From: [REDACTED]
Sent: 11 January 2019 08:51
To: Planning
Subject: 111 Roundstone Drive - EP/175/18/HH

Re: 111 Roundstone Drive, East Preston, Littlehampton, West Sussex, BN16 1EN.
Planning ref: EP/175/18/HH - Householder Application for the Demolition of Existing Outbuilding & Sunroom and Proposed Part Single-Storey / Part Two-Storey Rear Extension and new Porch.

Proposed East (Side) Elevation 1:100

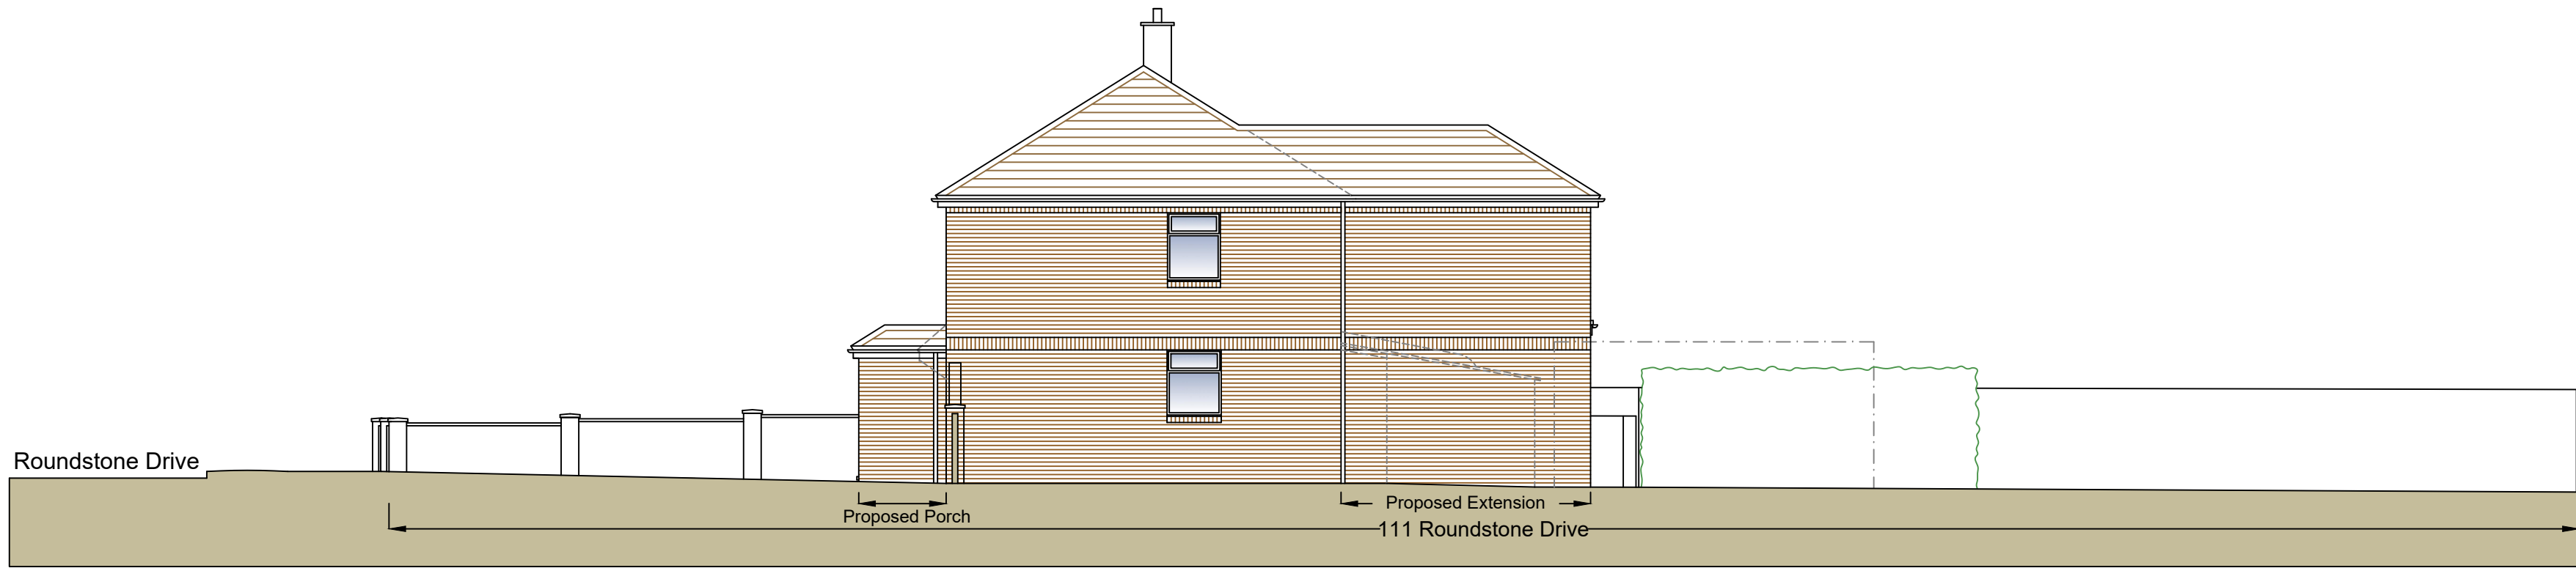
2. ‘Two storey extension would be very visible from the twitten adjacent to the property.’
Please find attached photographs to show that the proposed rear extension would not be very visible from the twitten. The first photo shows that 111 Roundstone Drive is the fifth property to the west of the twitten and the following 3 photos show the view from the twitten looking south-west taken at an eye level of approximately 6m high. It is not possible to view across to 111 Roundstone Drive from the southern end of the twitten due to the high fencing and planting, so the only possible view from the twitten is from the north end looking south west. As the photos show, at most only a very partial part of the roof and the chimney is visible due to the existing evergreen planting and overall distance, so the proposed matching tiled pitched roof to the two-storey extension would not be any more visible or create an overbearing profile.

Proposed North (Rear) Elevation 1:100

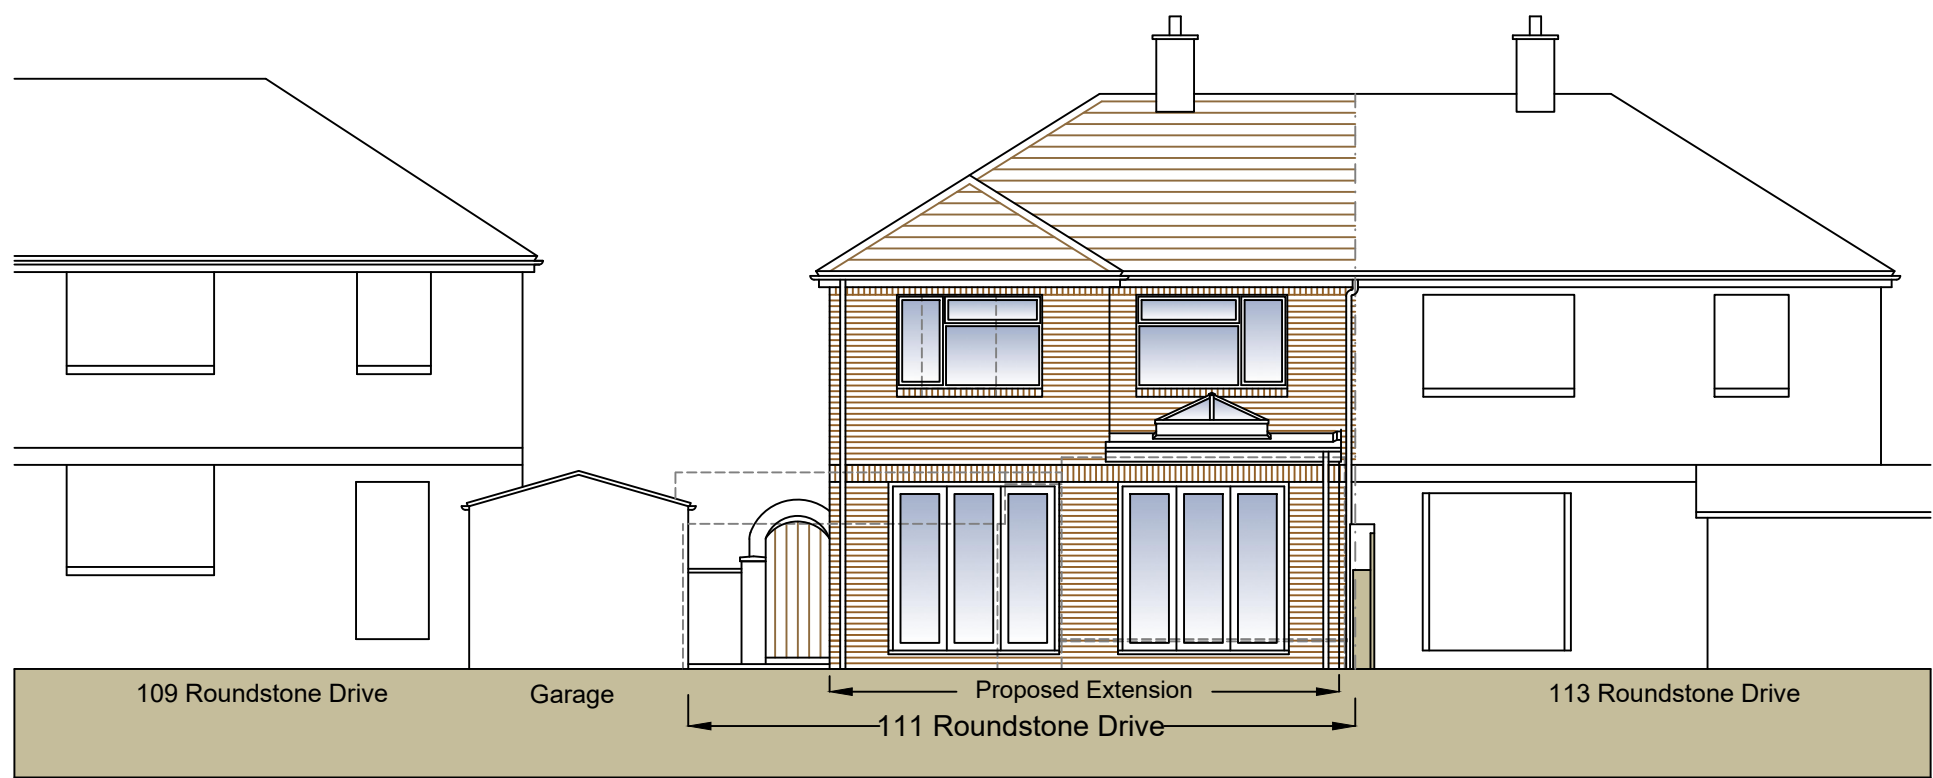
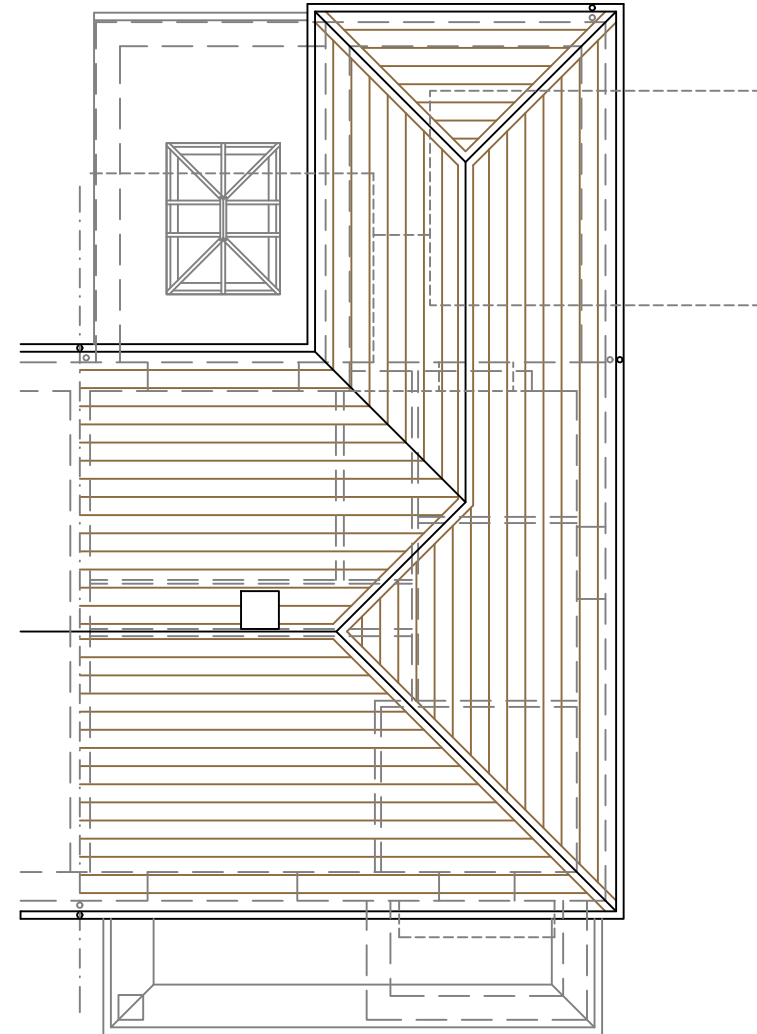
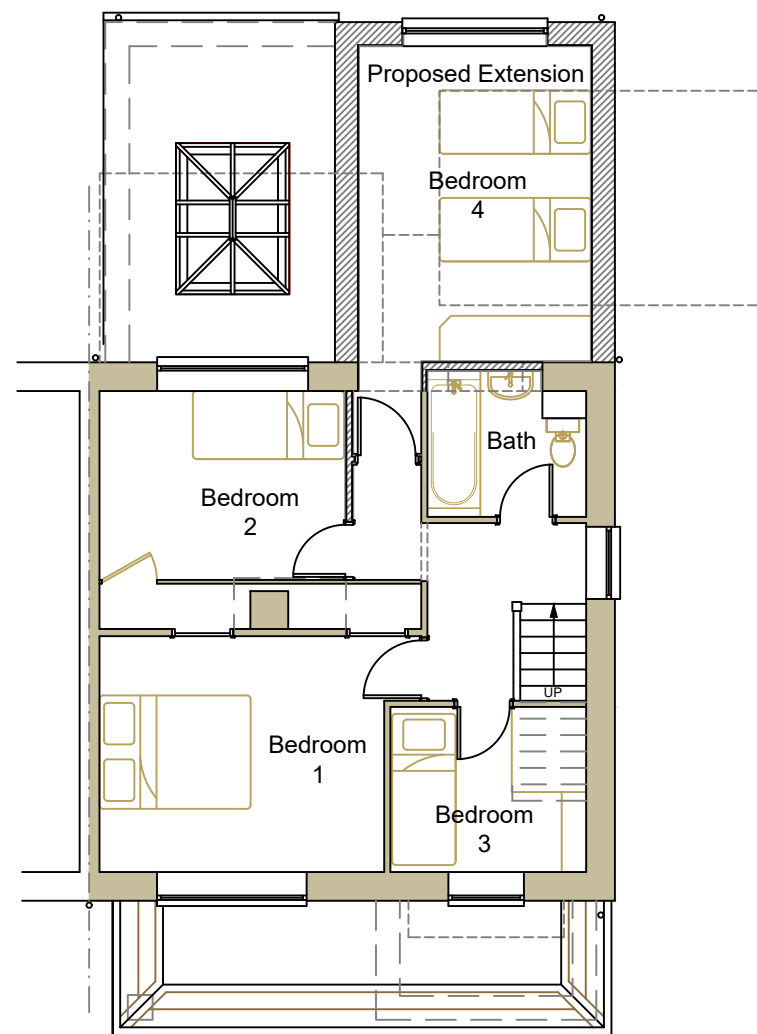
1. 'Overshadowing, overlooking or overbearing effect on neighbouring properties.'
Throughout the design stage of the project, and although the clients originally wanted a full width two-storey rear extension, we were conscious of ensuring that the proposals would have a minimal impact on the

neighbouring properties to avoid overshadowing, overlooking and overbearing, so hence the part two-storey, part single storey proposal and narrow first floor bedroom. Prior to submission of the planning application, the applicants met with the owners of both the neighbouring properties at no. 109 and 113 Roundstone Drive and discussed their drawings and the proposals to make sure that they were all happy with what was being proposed before going any further. Both parties gave their approval and neither have objected to the application.
